Our Ref: M/62/20/NMA

Non-material amendment following grant of M/100/18/HH to reduce the total area of extension from the previously described proposals, to only the ground floor replacement of the existing conservatory with a side extension of 15m² along the kitchen edge, with 3 No. flat roof windows.

9 Farm Close Elmer Middleton-On-Sea PO22 6JQ

Drawing number: 66/18/07
Drawing name: Amended Floor plan proposed
Scale: 1:50@A3
Date: 19 August 2020

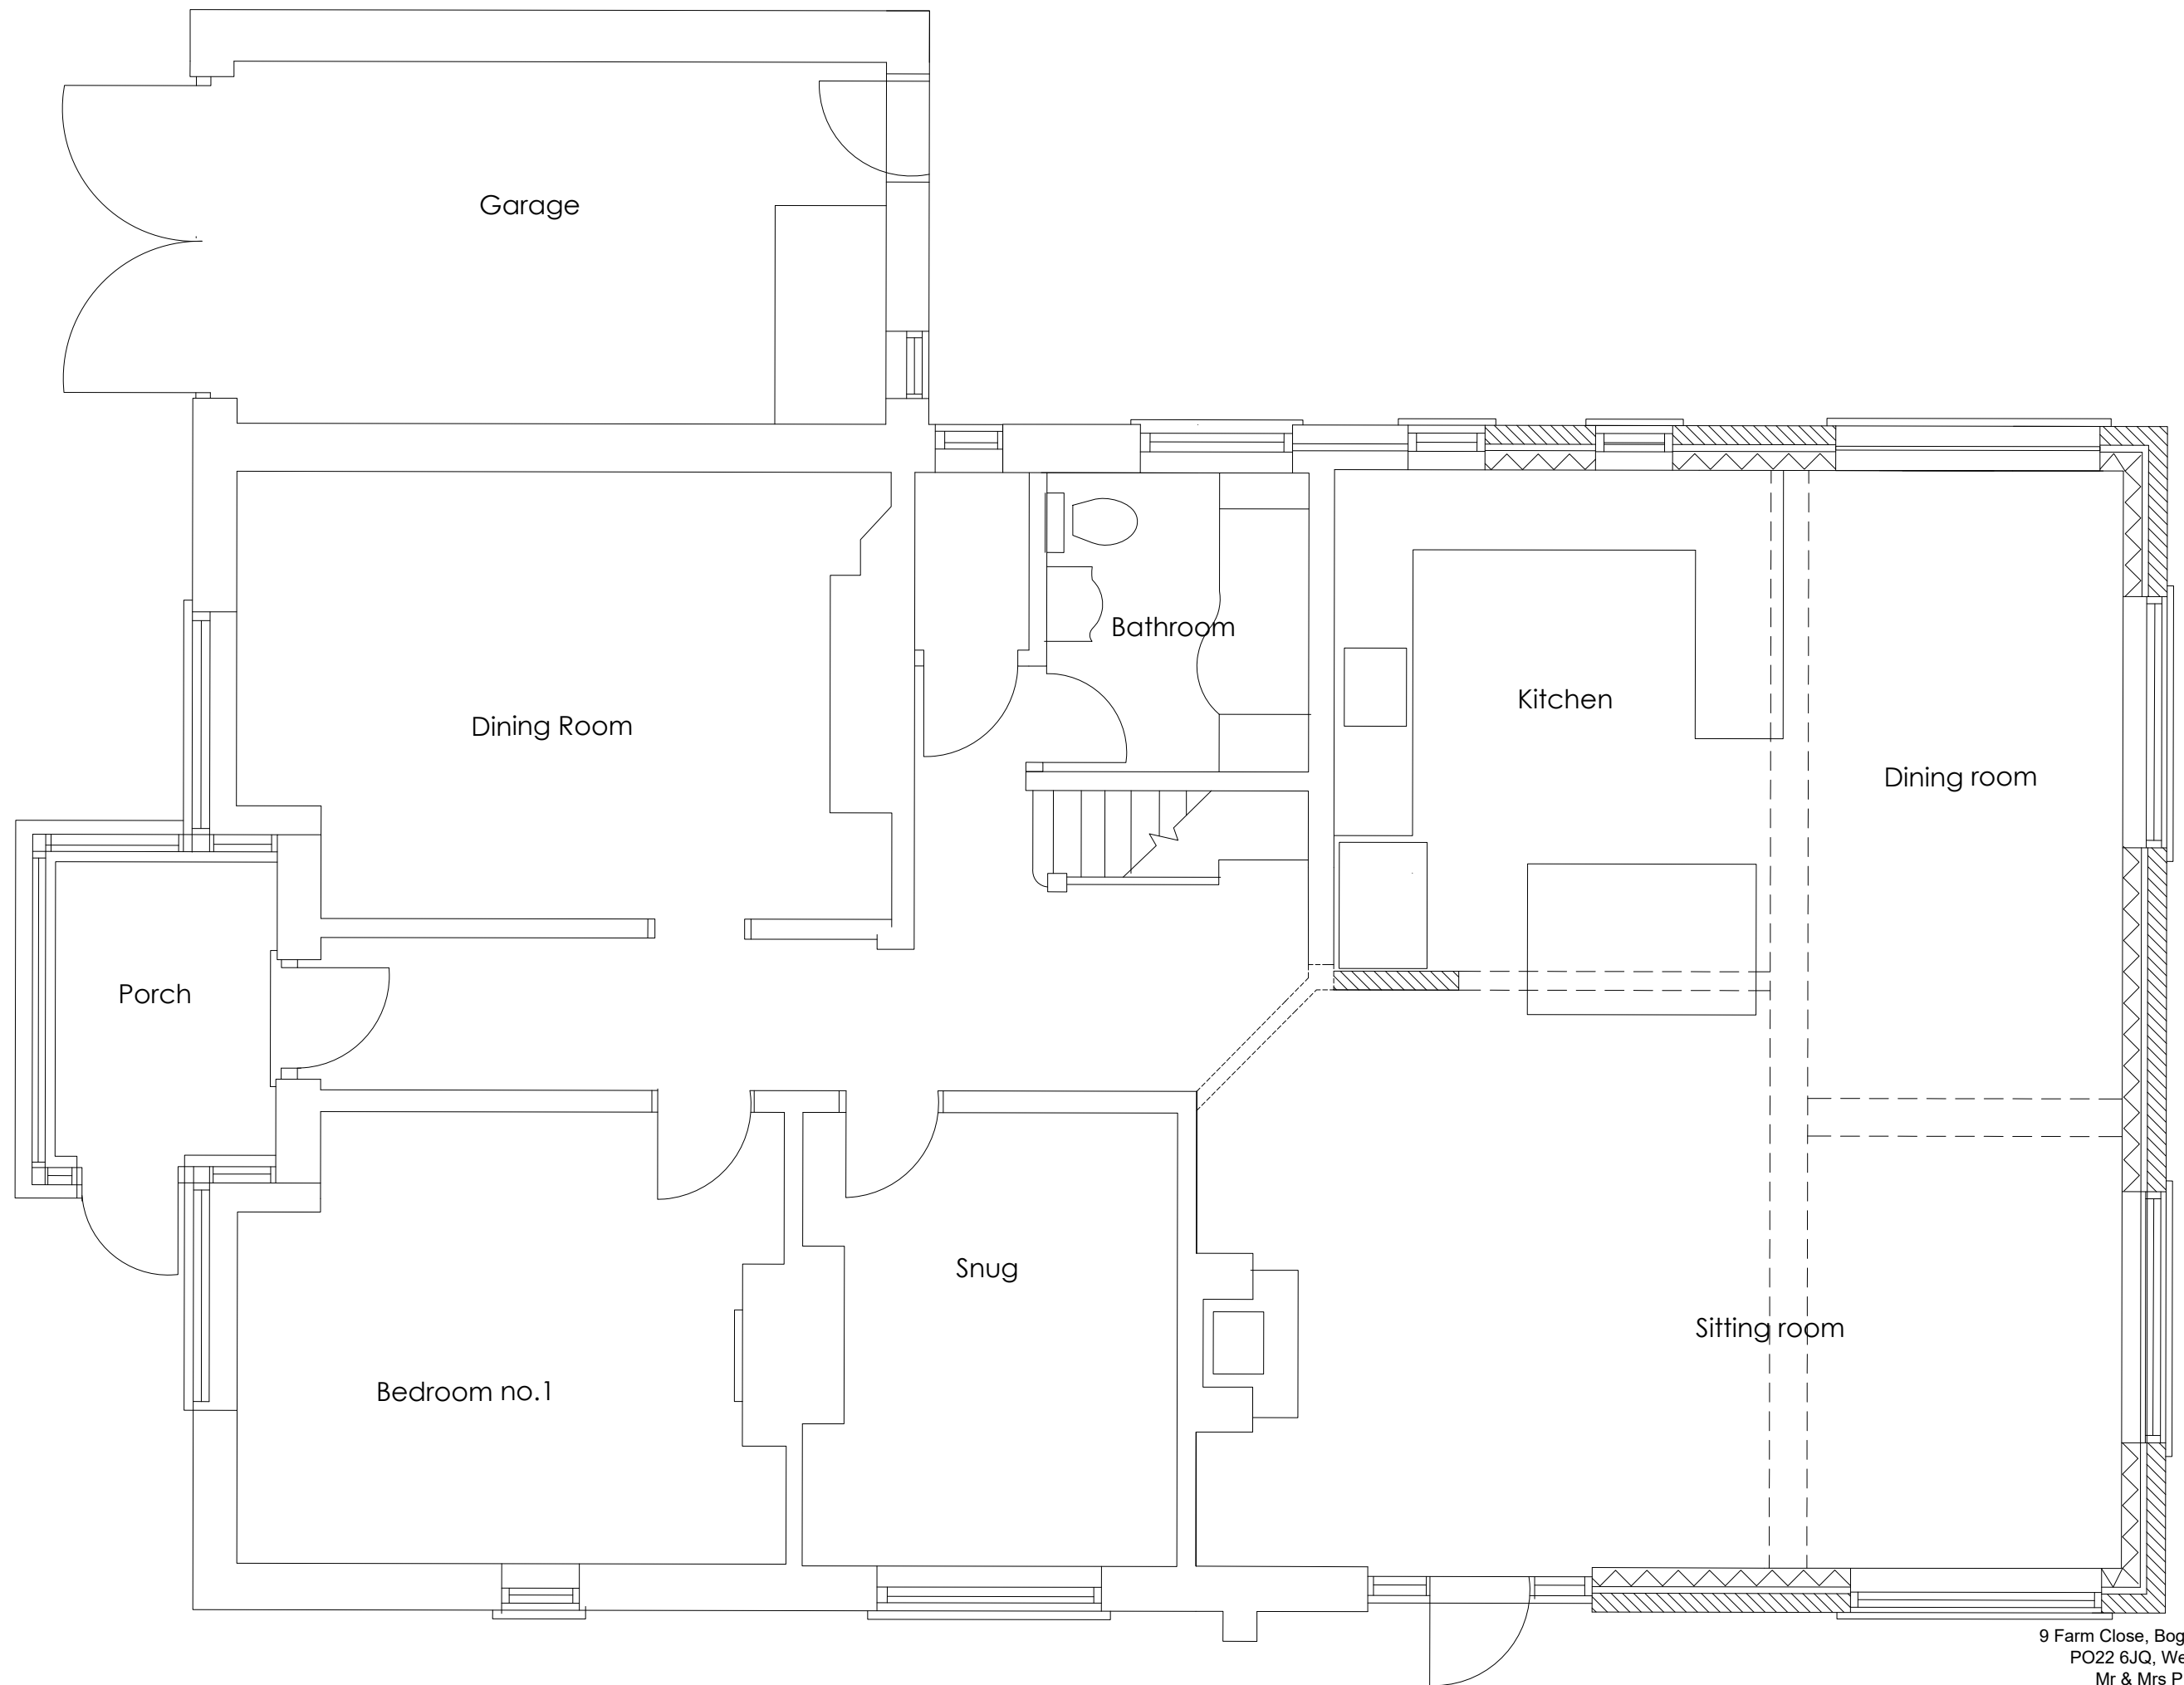
I refer to your recent application for a Non Material Minor Amendment. I note that you seek to alter the extensions as previously described, involving an increase in width of the rear extension.

The reason this proposal has not been accepted as a Non-Material Amendment is because the proposed changes exceed the maximum increase in scale allowable under the criteria. In this case, due to the increase in width of the rear extension (to be used as a dining room) being over 1m a new application will need to be submitted.
